From: Julie Grieves
Sent: 20 November 2019 11:04
To: [REDACTED]
Subject: BE/117/19/HH - 29 Westfield, Bersted

It has come to our attention that the application processed for the above address is incorrect. The following matters need attending to before the application can 'go live' again

Location plan 1:1250

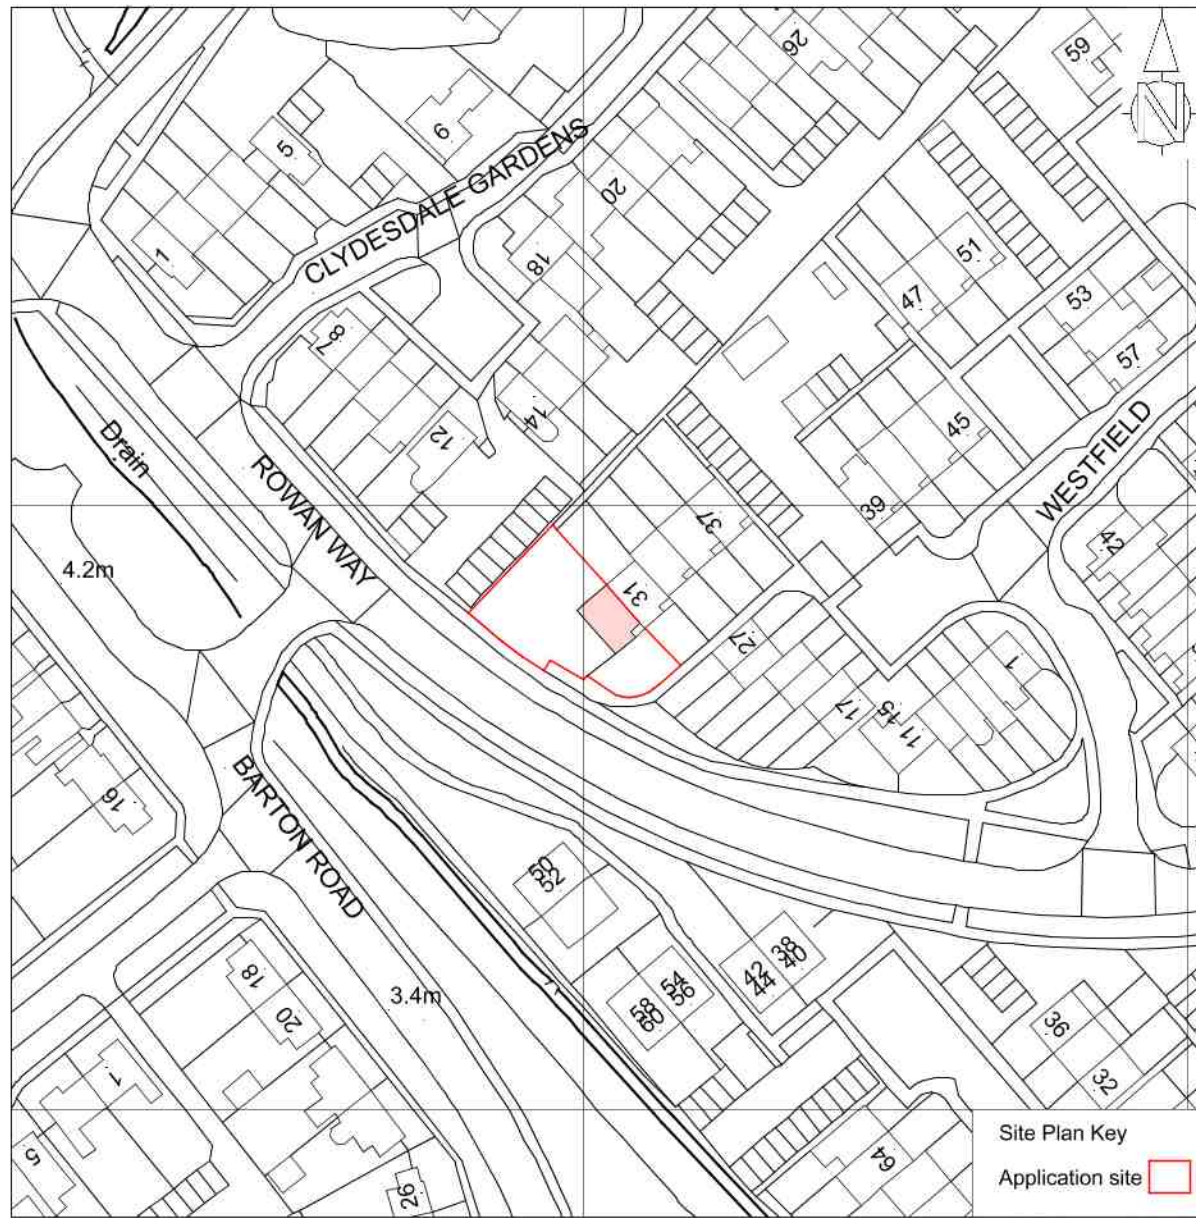
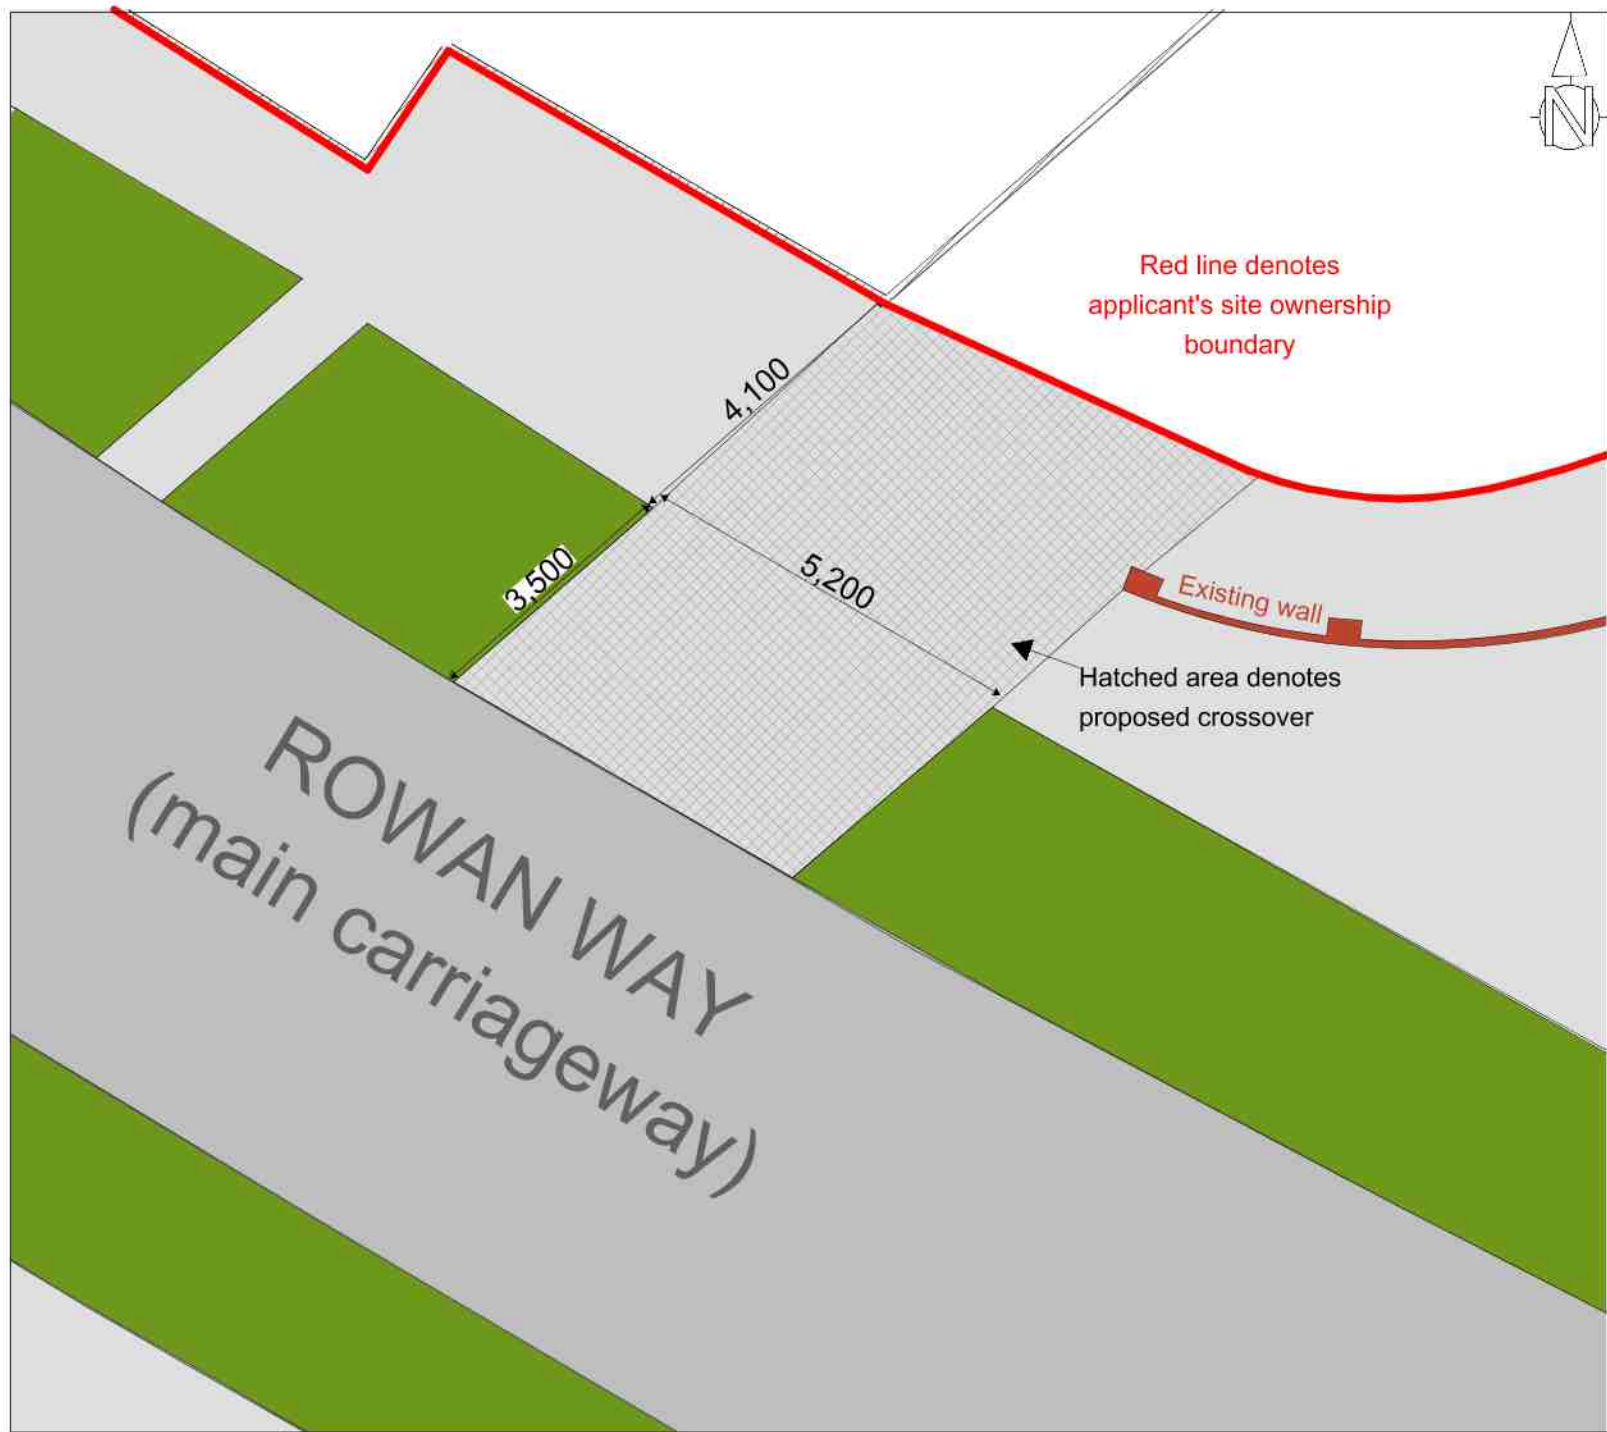
1. As the works involve highway land, Certificate B on the application form needs to be signed and a Article 13 Notice needs to be served on West Sussex County Council (attached)
<https://www.arun.gov.uk/download.cfm?doc=docm93jjm4n6775.pdf&ver=6487>
2. The red edged site area **MUST** include all areas that form part of the application. Therefore the wall & drop kerb must be included within the red edge.
3. The block plan must show the position of the proposed works highlighted as clear visibility splays. This information can be found at West Sussex County Council.

3. I have amended the plans to show the application site, outlined in red, including the drop kerb and wall.

4. I have also amended the plan to clearly show the proposed works highlighted as clear visibility splays.

Location plan 1:1250

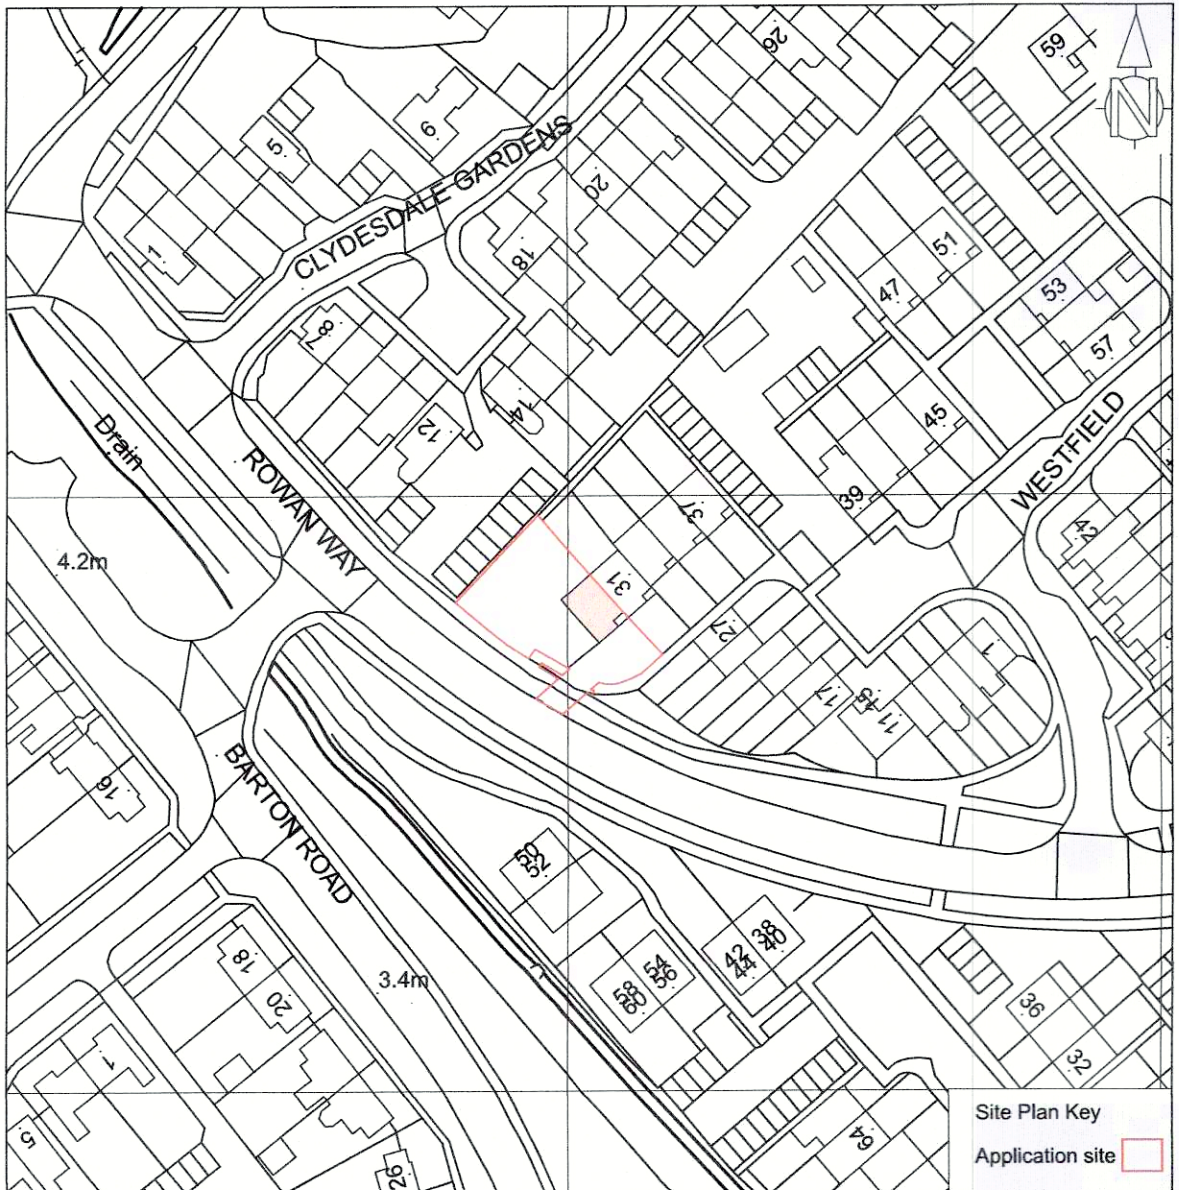
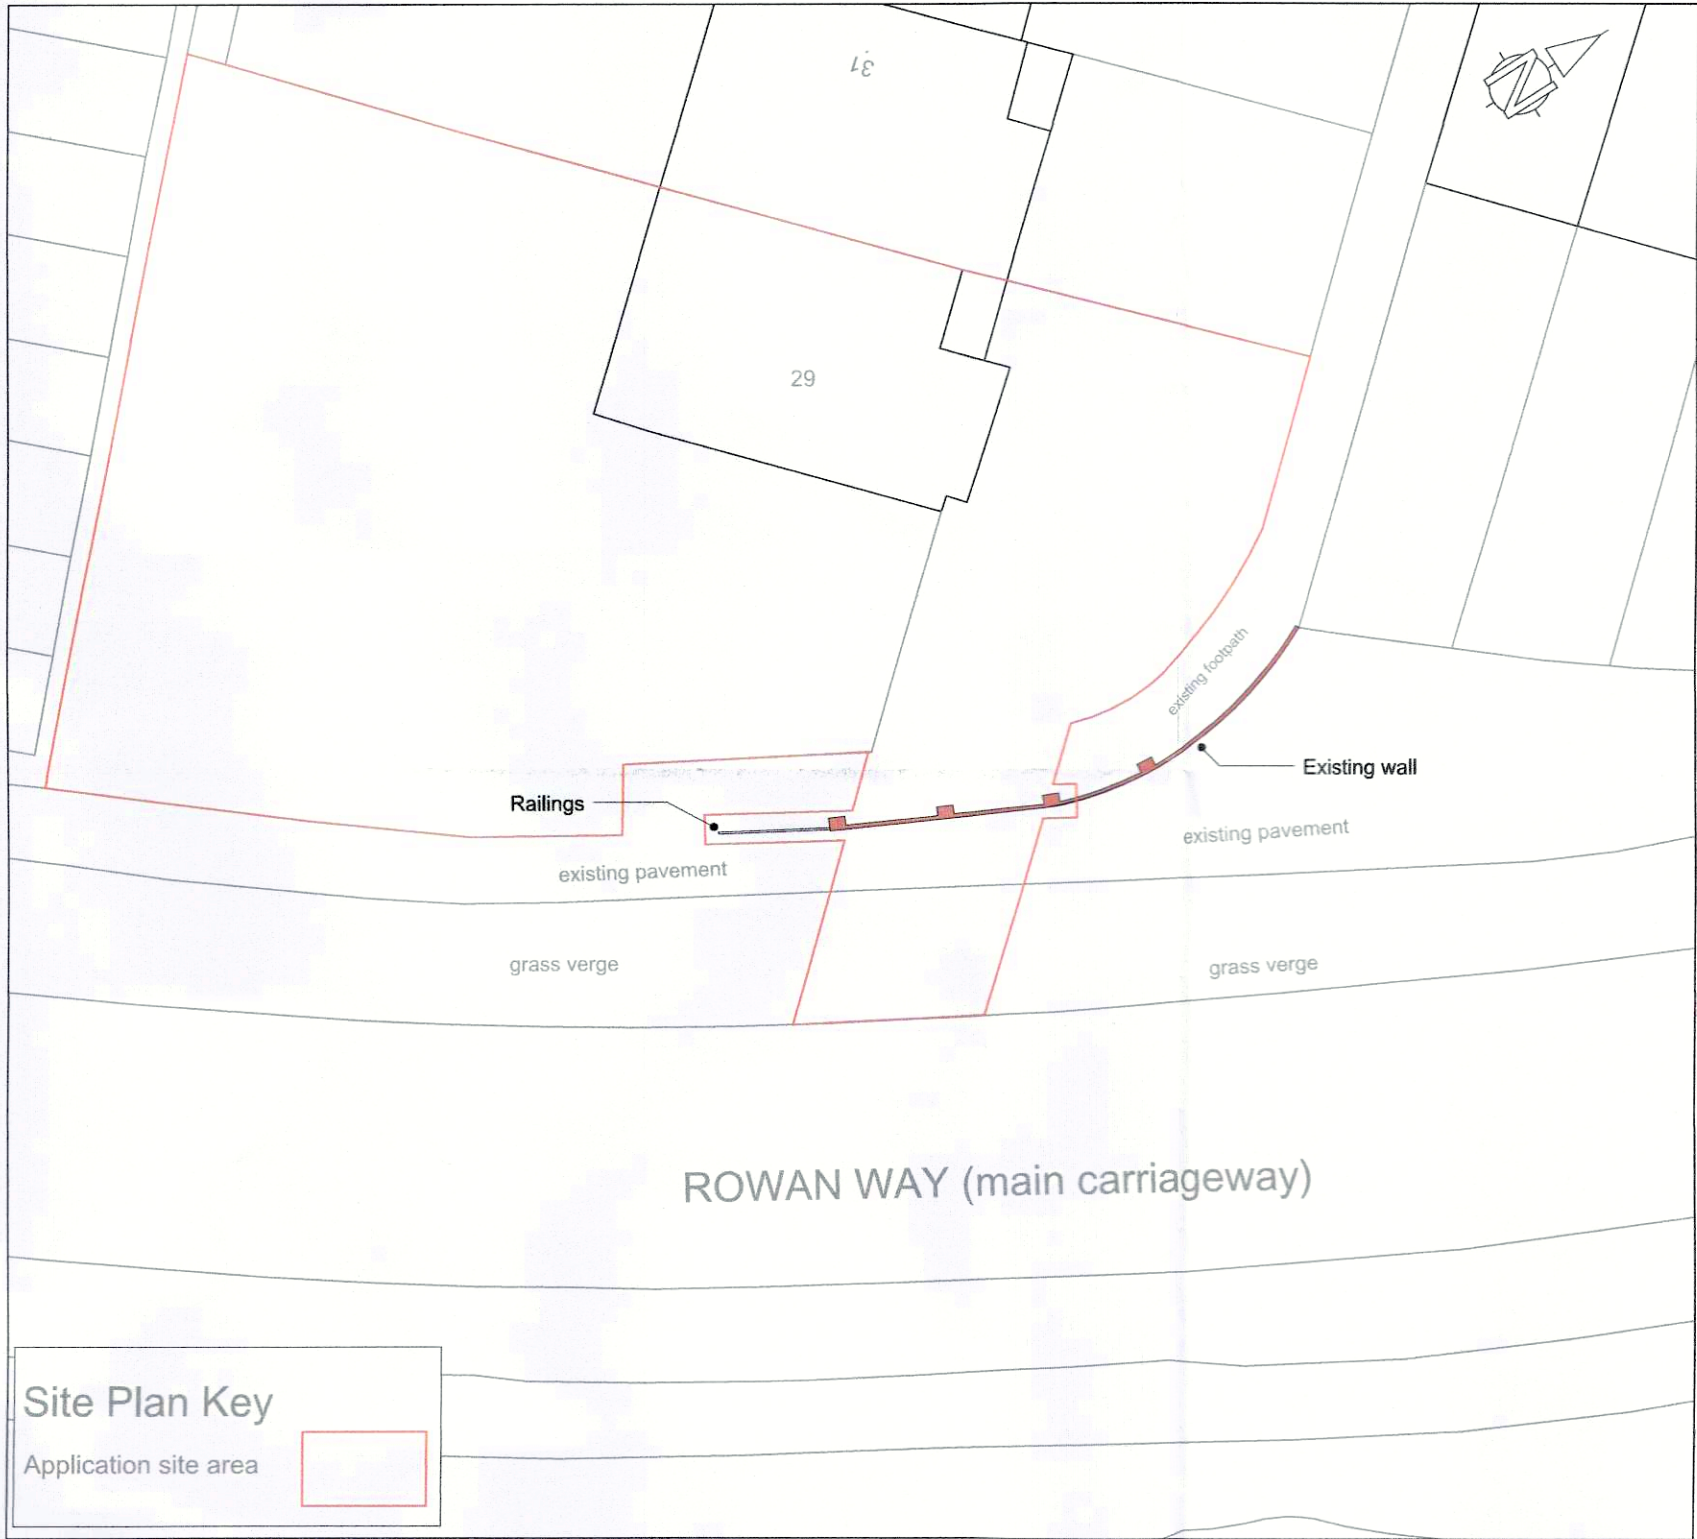
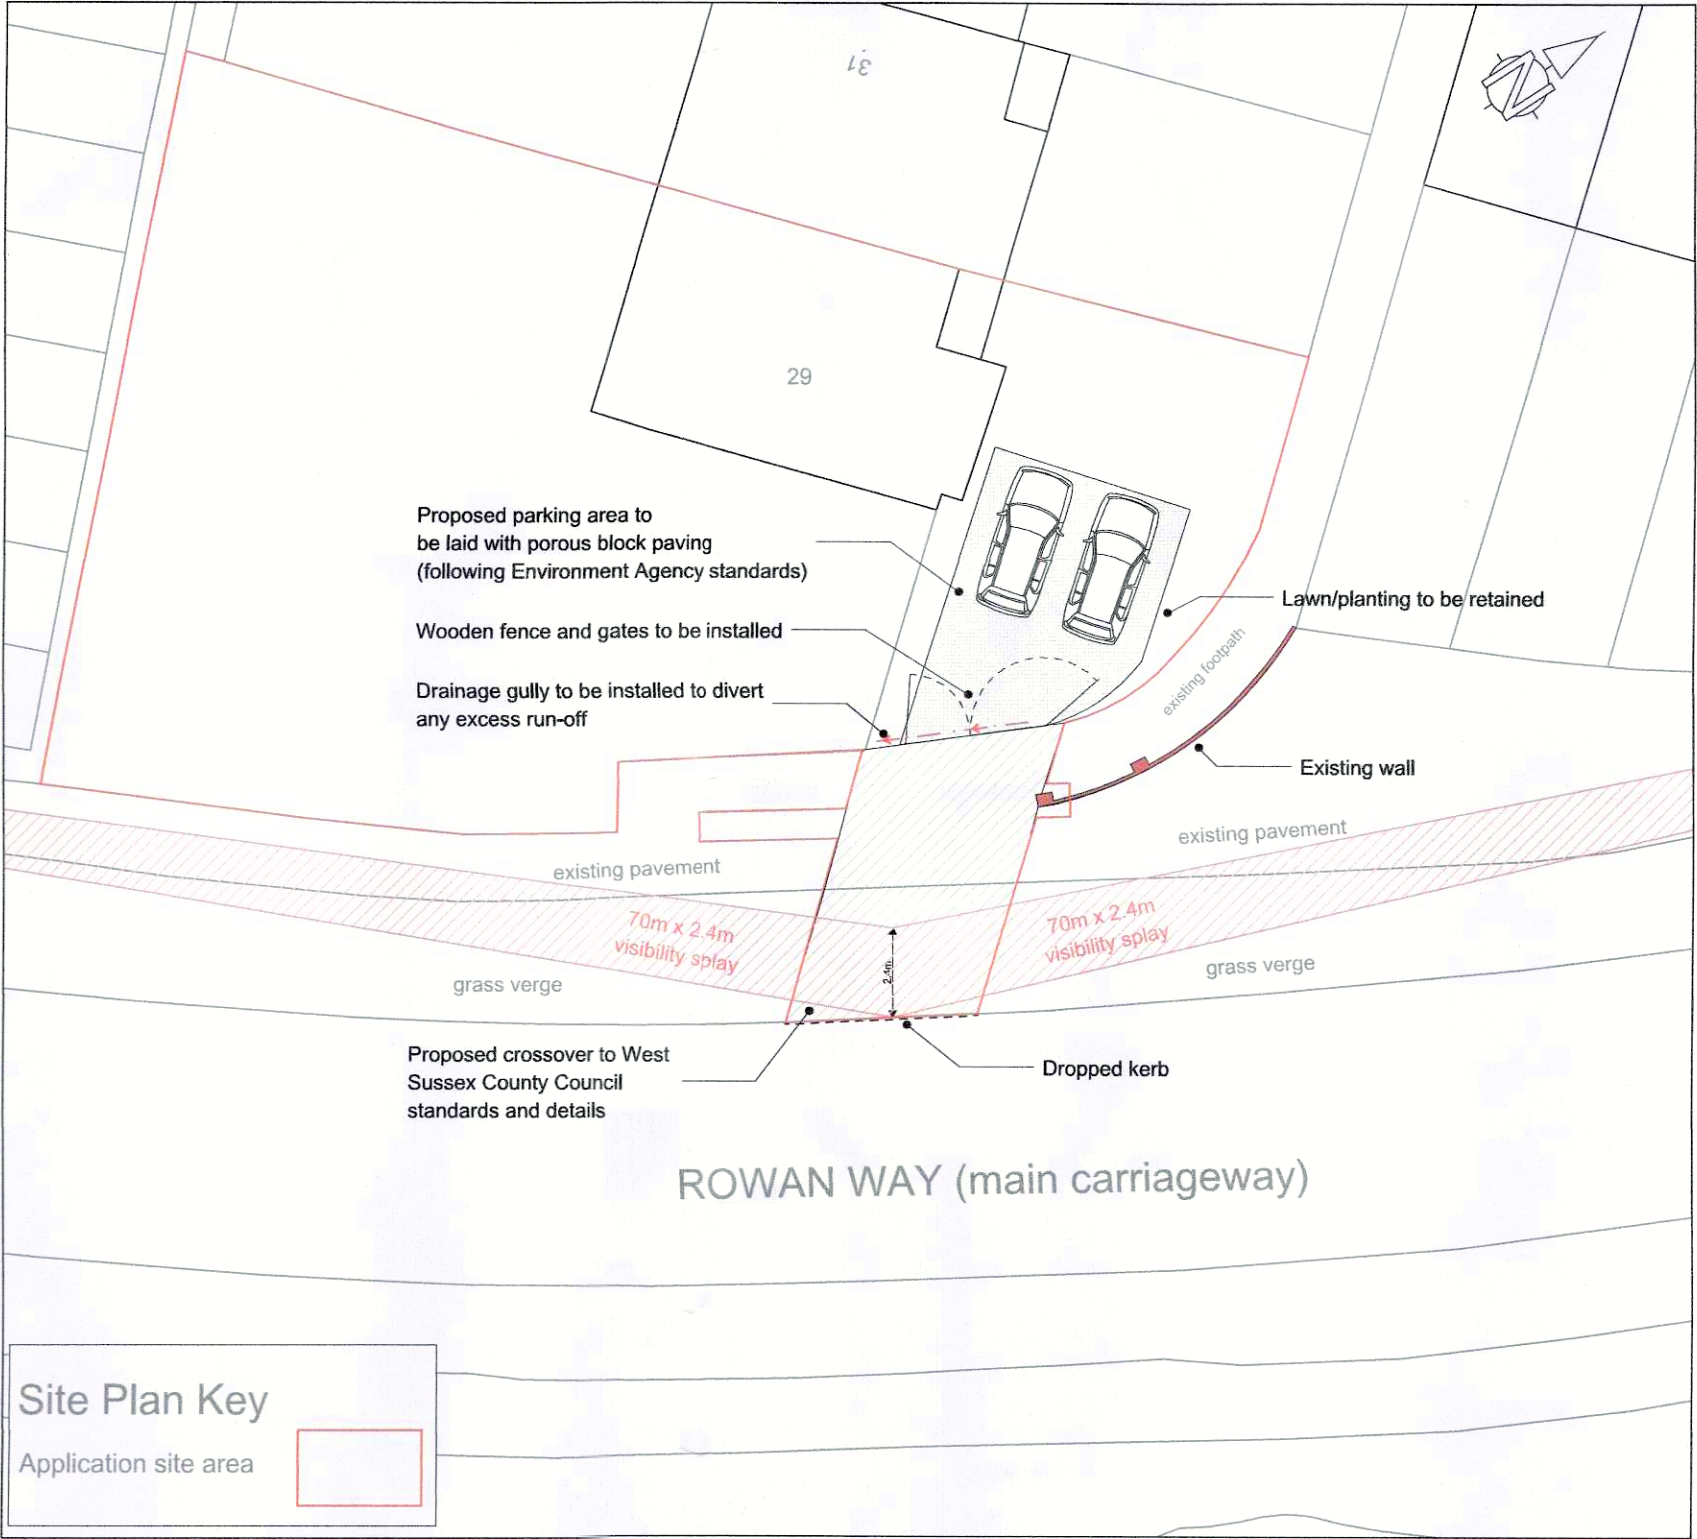
The location/block is still incorrect. The wall needs to be within the application site area as it forms part of the application.

I've amended the location/block plans to include the parts of the wall and railings which will be removed plus a small part of the existing wall which requires repairs.
